TRADITIONAL ARCHITECTURE GROUP

TAG PEER REVIEW- WOODFOLD VILLA, SHORROCK GREEN, MELLOR, 19 May 2022

The TAG Peer Review Group was invited by Francis Shaw of Shaw Jagger, the applicant's agent, to review the developing scheme subsequent to a pre-application submission with the local authority.

The application is to be made as an NPPF clause 80e application.

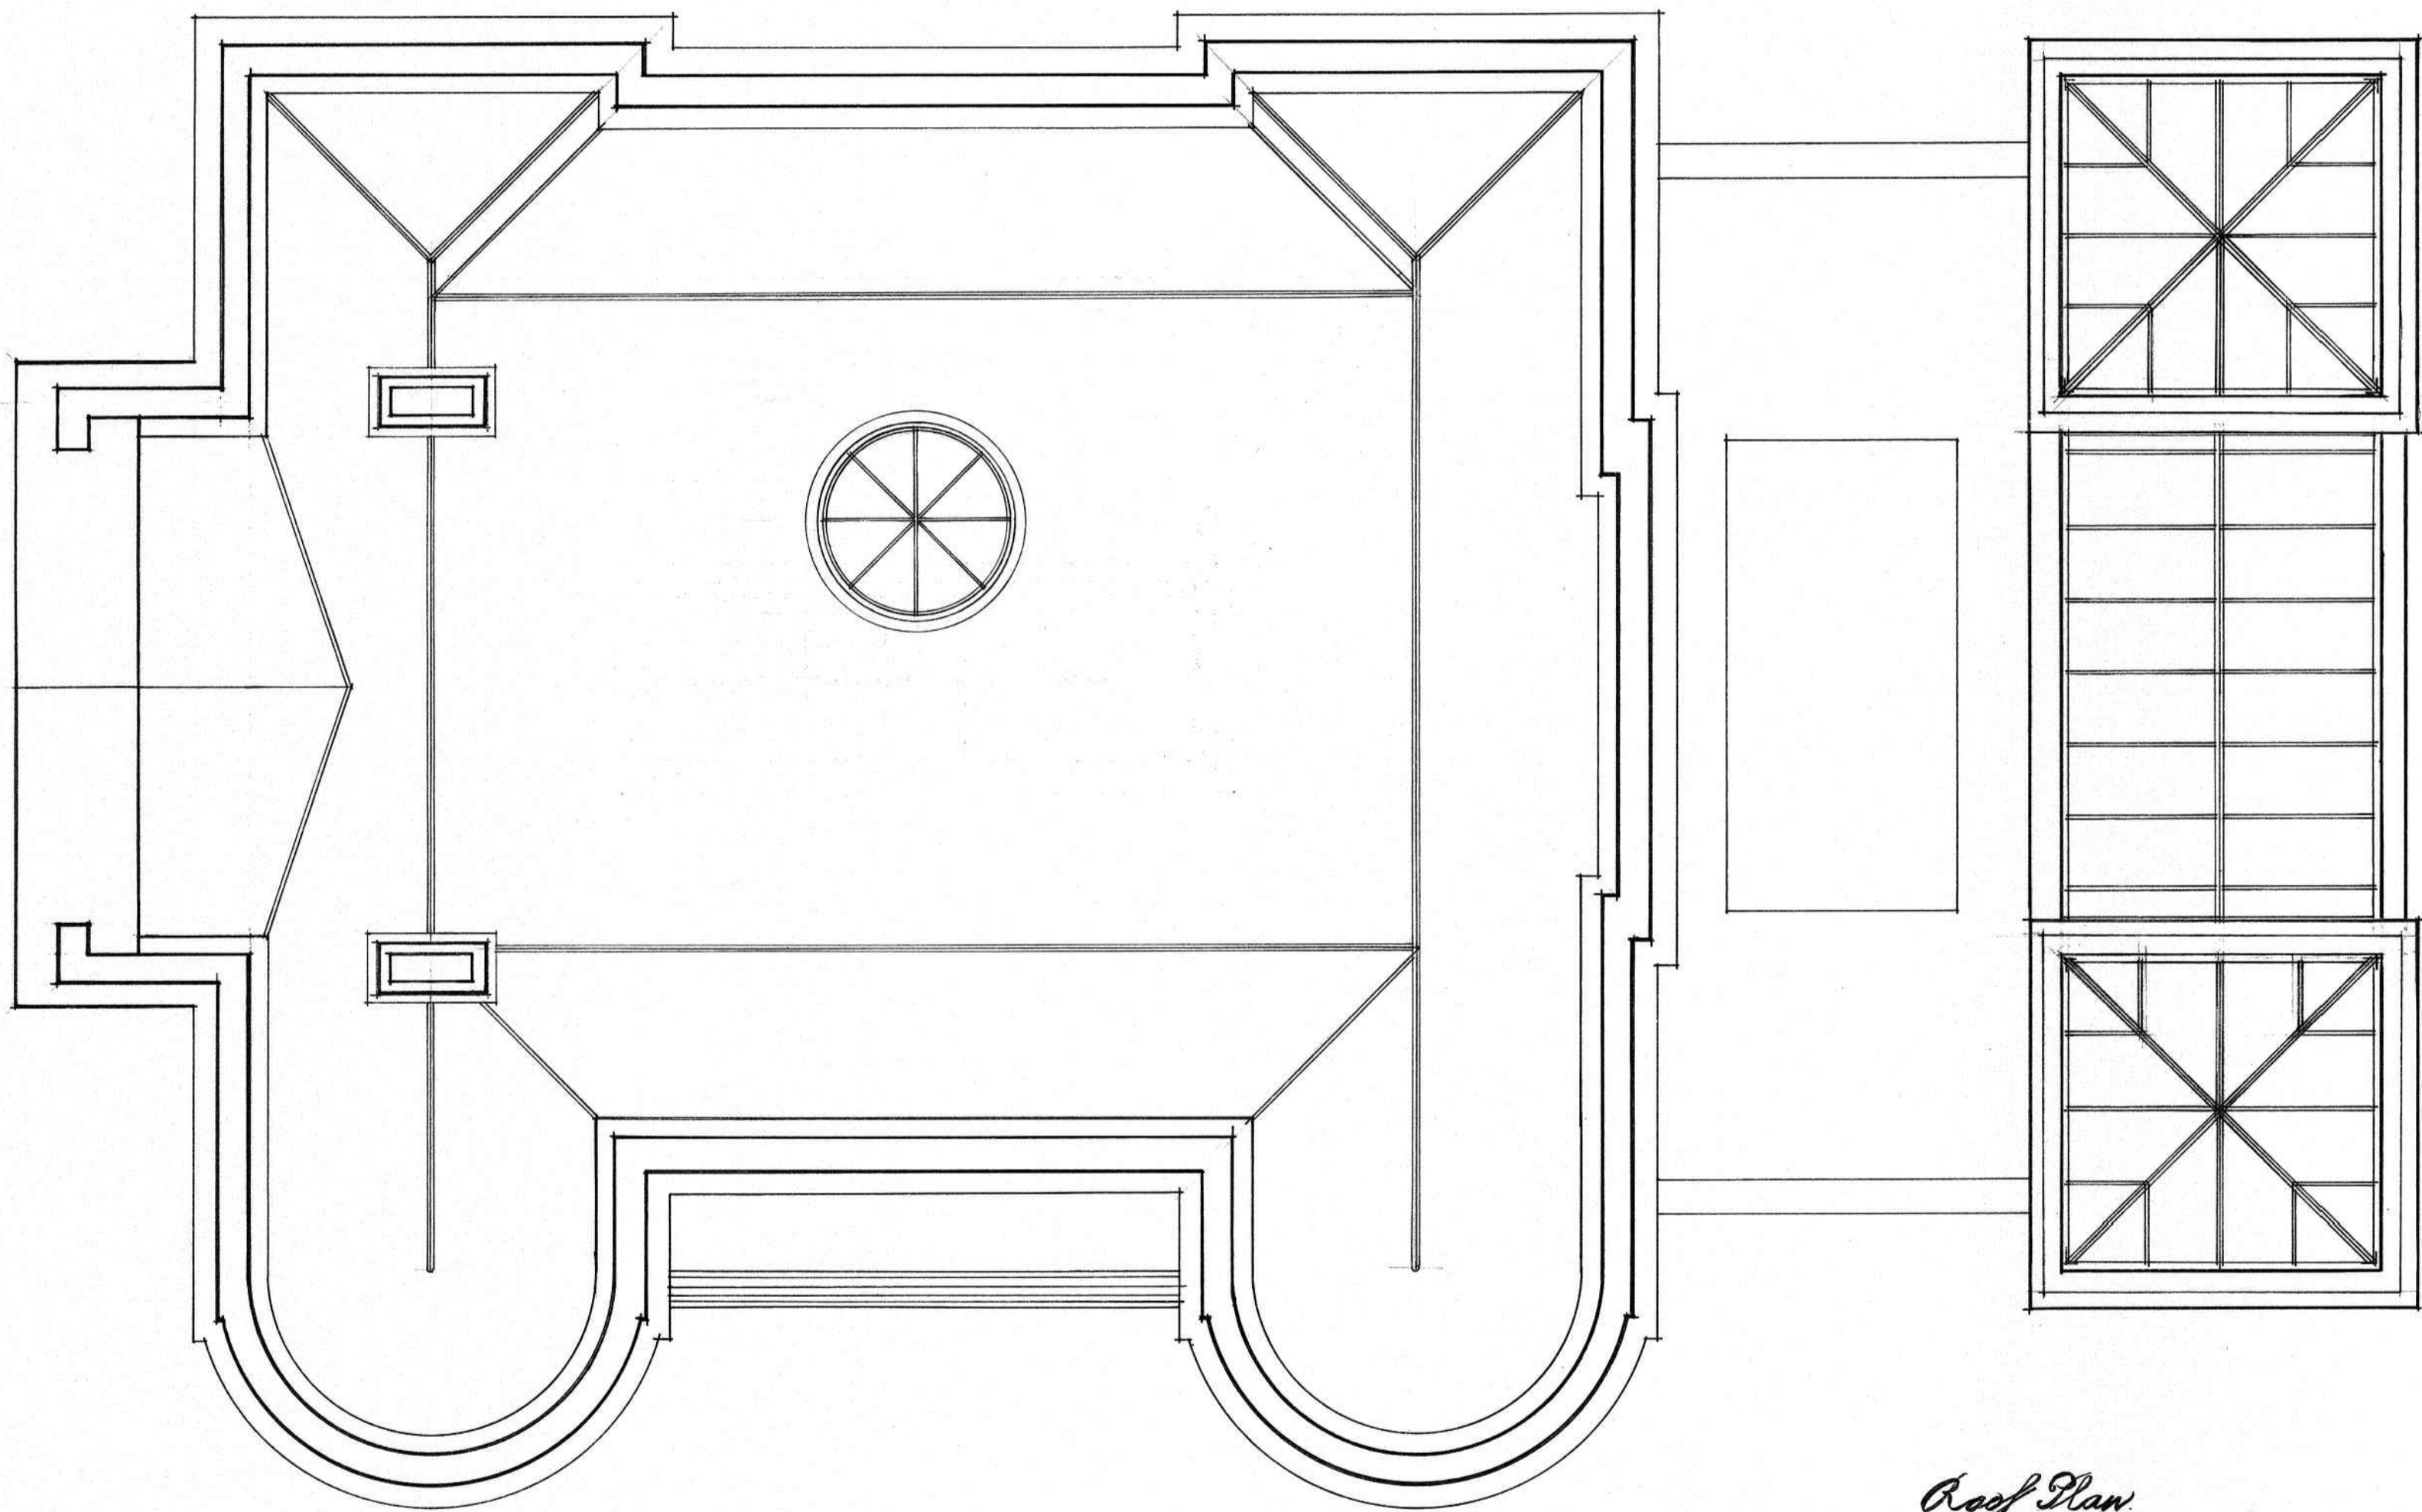
Glass roof of the orangery- Does this need to be fully glazed or is there a different configuration to reduce the amount of glass proposed?

The separation of orangery and pool house might be better expressed through a change in the parapet detailing. Possibly more solid parapet detail over the pool building. Perhaps the use of a solid parapet is an approach that will avoid having to re-consider the height of the orangery or pool building whilst demonstrating hierarchy or differentiation.
